WEST SUSSEX COUNTY COUNCIL CONSULTATION

TO:	Arun District Council FAO: Simon Davis
FROM:	Highways, WSCC
DATE:	23 rd July 2018
LOCATION:	Land at, 10-12, Devonshire Road, Bognor Regis, West Sussex, PO21 2SX
SUBJECT:	BR/173/18/DOC Approval of details reserved by condition imposed under BR/306/16/PL relating to conditions 3-surface water drainage, 5-landscape scheme, 6- schedule of materials & finishes, 8-refuse & recycling bin enclosure & 9- covered & secure cycle parking spaces.
RECOMMENDATION:	☒ Advice ☐ Objection ☐ Modification ☐ No Objection ☐ More Information ☐ Refusal
S106 CONTRIBUTION TOTAL:	£N/A

West Sussex County Council, as the Local Highway Authority (LHA), has been consulted on discharge of conditions secured under BR/306/16 (6 x flats). Condition 9 refers to the provision of secure and covered bicycle storage.

CLIENT'S NAME	Hurston Estates
JOB TITLE	10-12 Devonshire Road Bognor Regis
DRAWING TITLE	Bin Store and Cycle Storage

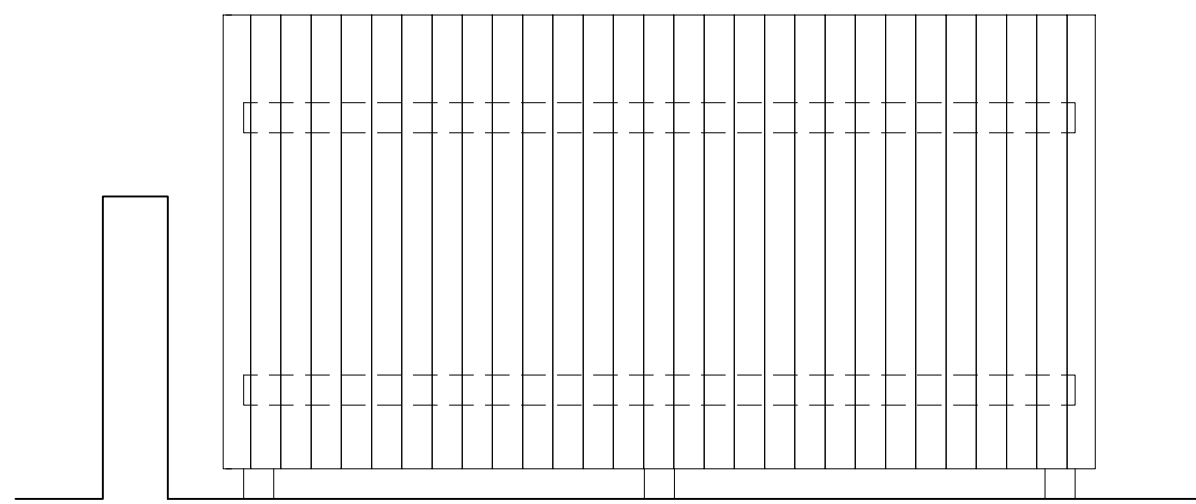
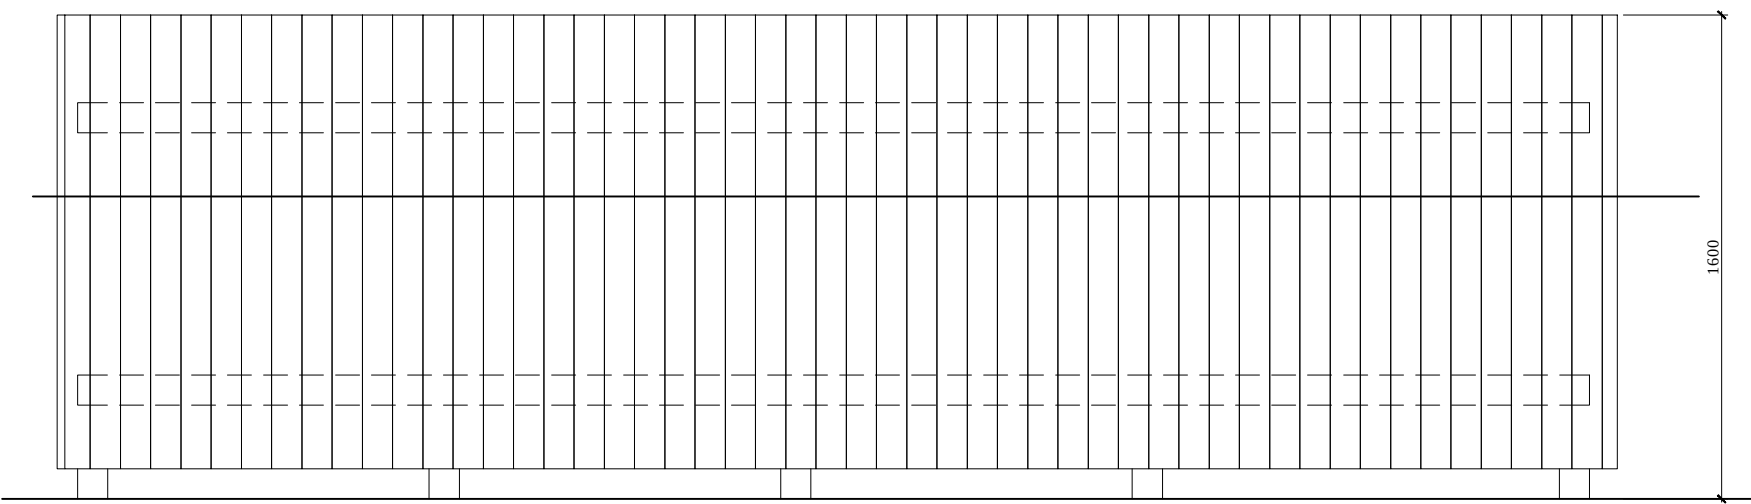
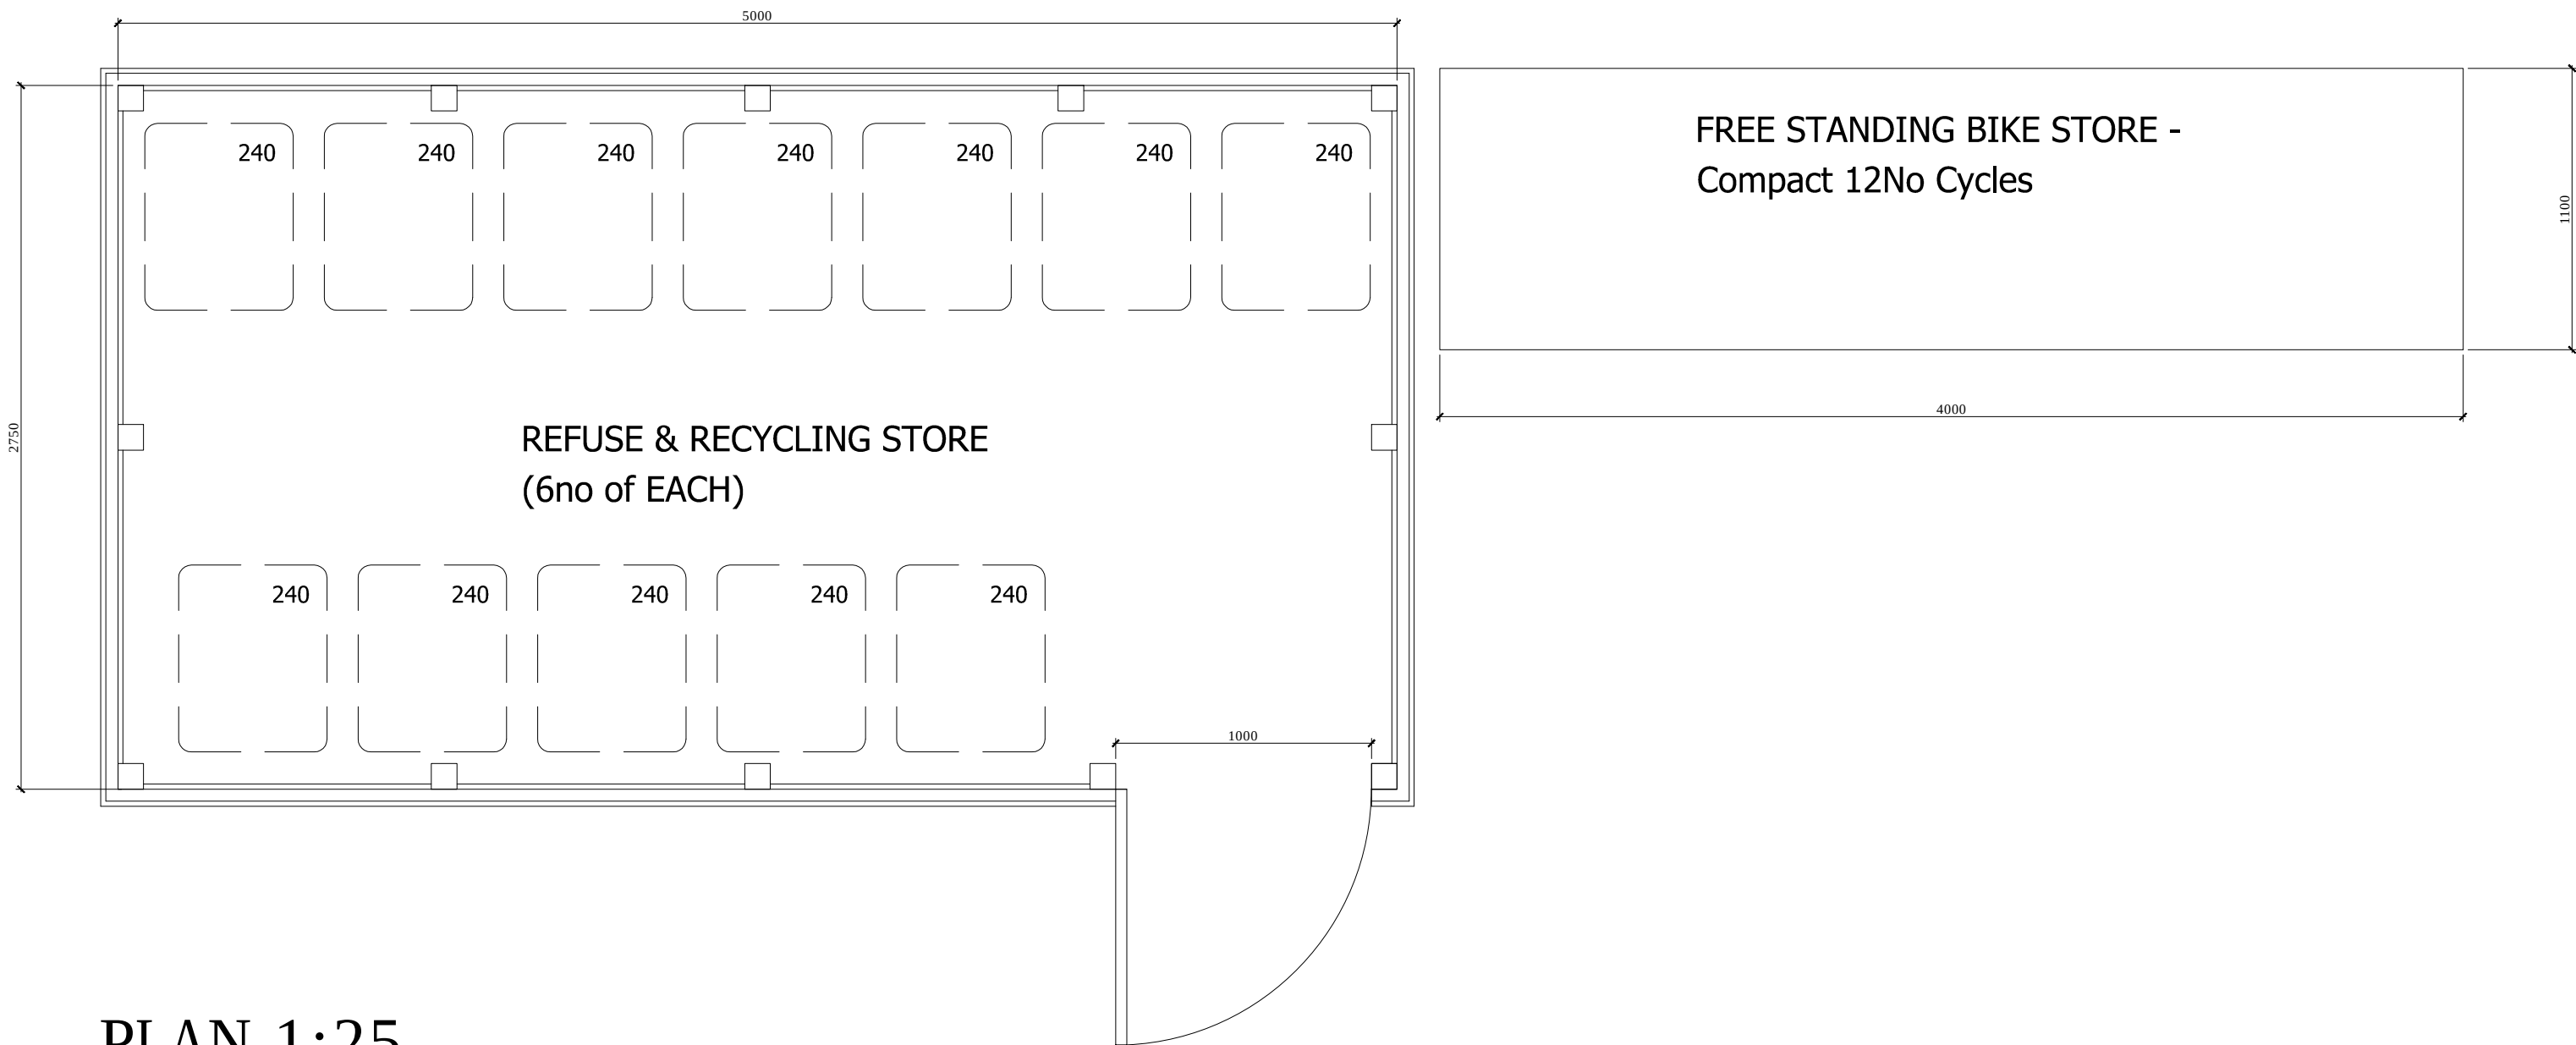
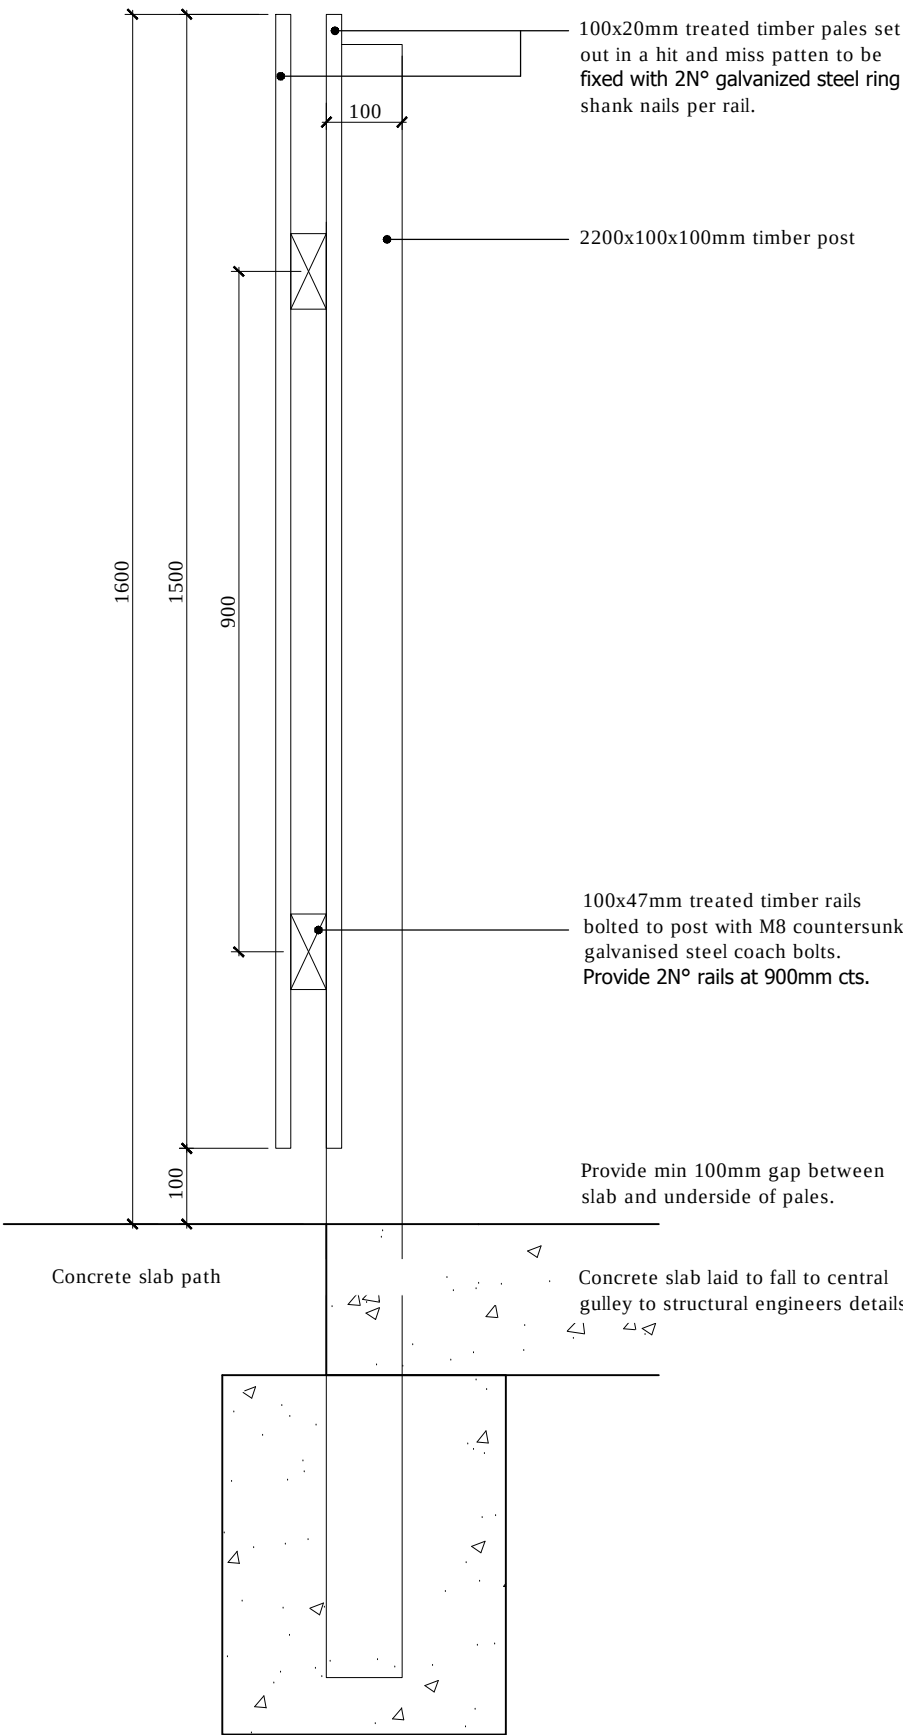
Plans and details have been provided detailing the cycle parking provisions and where this will be located within the site. This will be capable of accommodating 12 cycles in a communal facility.

The plans and details pertaining to condition 9 are acceptable.
